**D14 Academic Building**

**Access Report  
prepared for UNSW  
Sydney  
Final v3**

**3 April 2019**

Ground Plan
Date
12.04.19
Project No. 18026
Drawing No. ADDA20000
Revision 05

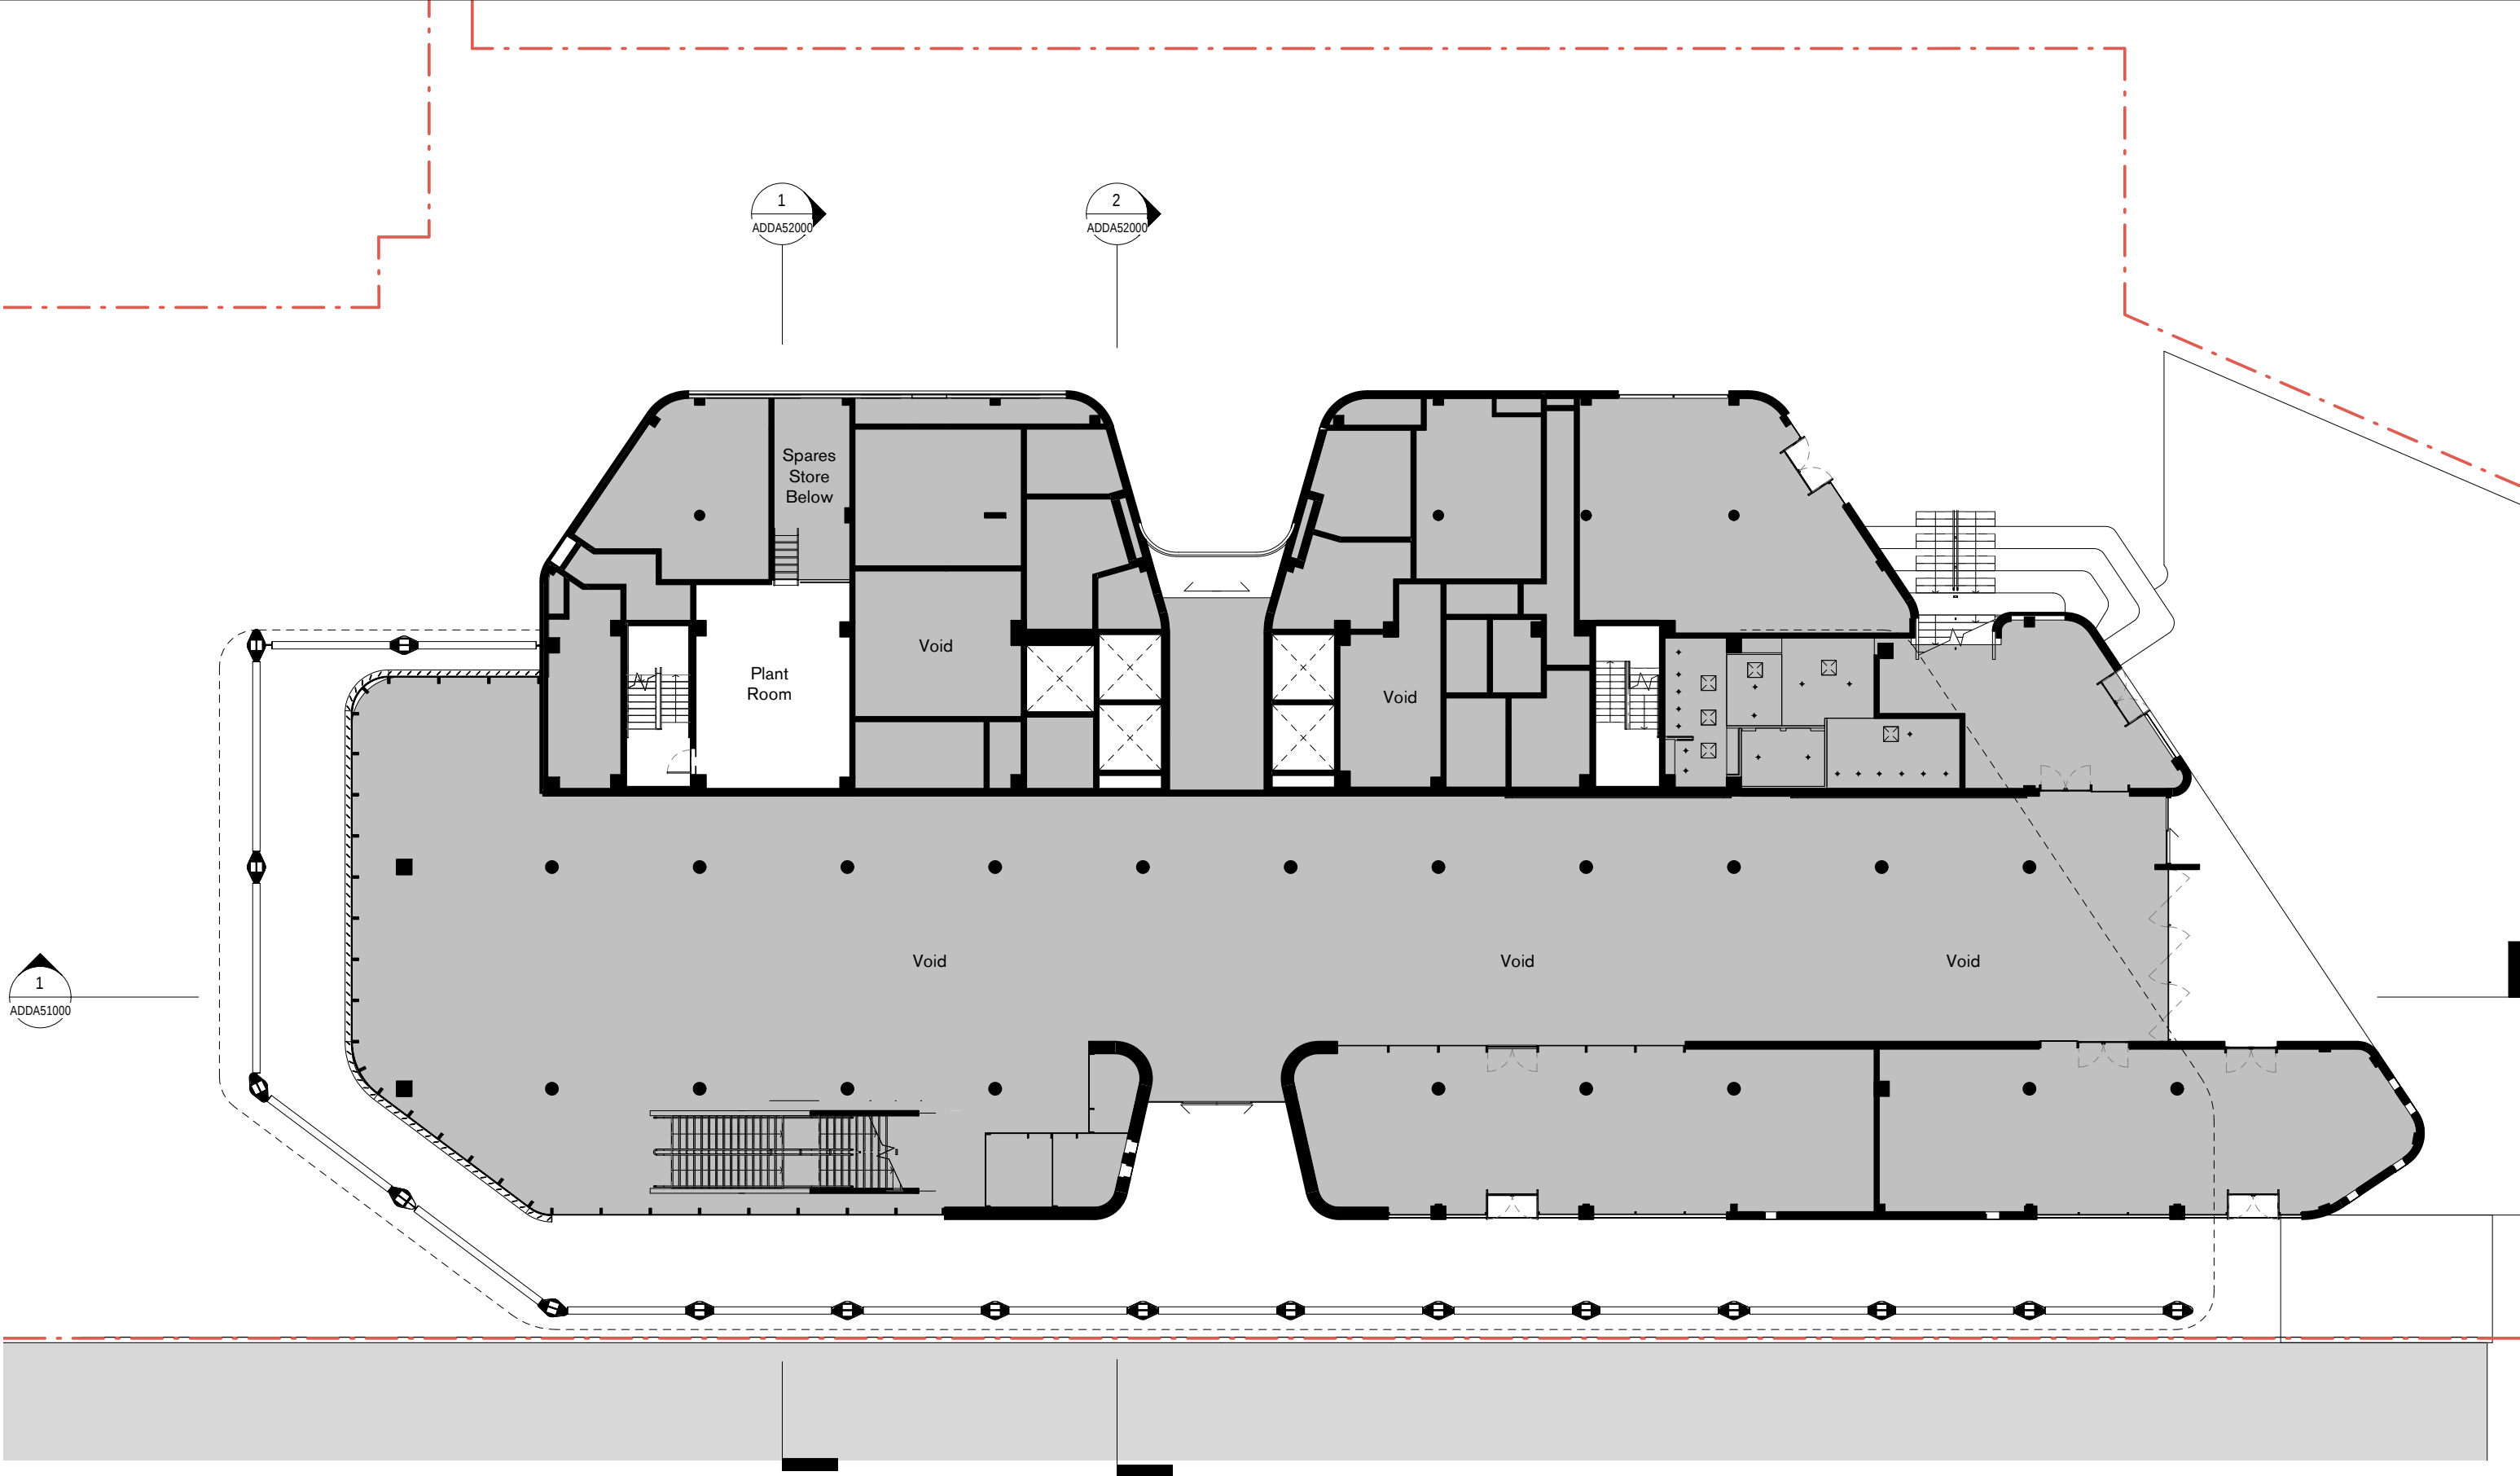
It is noted that there will be a new truck service bay on Third Avenue on Ground Level in the north-west sector of the building, as shown on drawing ADDA20000. The truck service bay will be on-grade with the adjacent pedestrian-only footpath. The vehicular path of travel will be designated as a 'shared zone'.

Insofar as trucks are sharing the same space as pedestrians, the trucks will pose a safety hazard for people with a disability. This is given that people with a disability may have not have the same capacity to detect an oncoming vehicle or, if they do detect an oncoming vehicle, they may not have the capacity to avoid that vehicle in time.

To address this safety risk for people with a disability, the area will require a package of safety measures. This could include, but would not be limited to, the following: restricted hours of use for vehicles, speed limits, contrasting flooring, bollards, and clear signage. Alternatively, the use of a kerb-and-gutter roadway would be advisable in lieu of a shared zone. This area will be appropriately addressed during the design development phase.
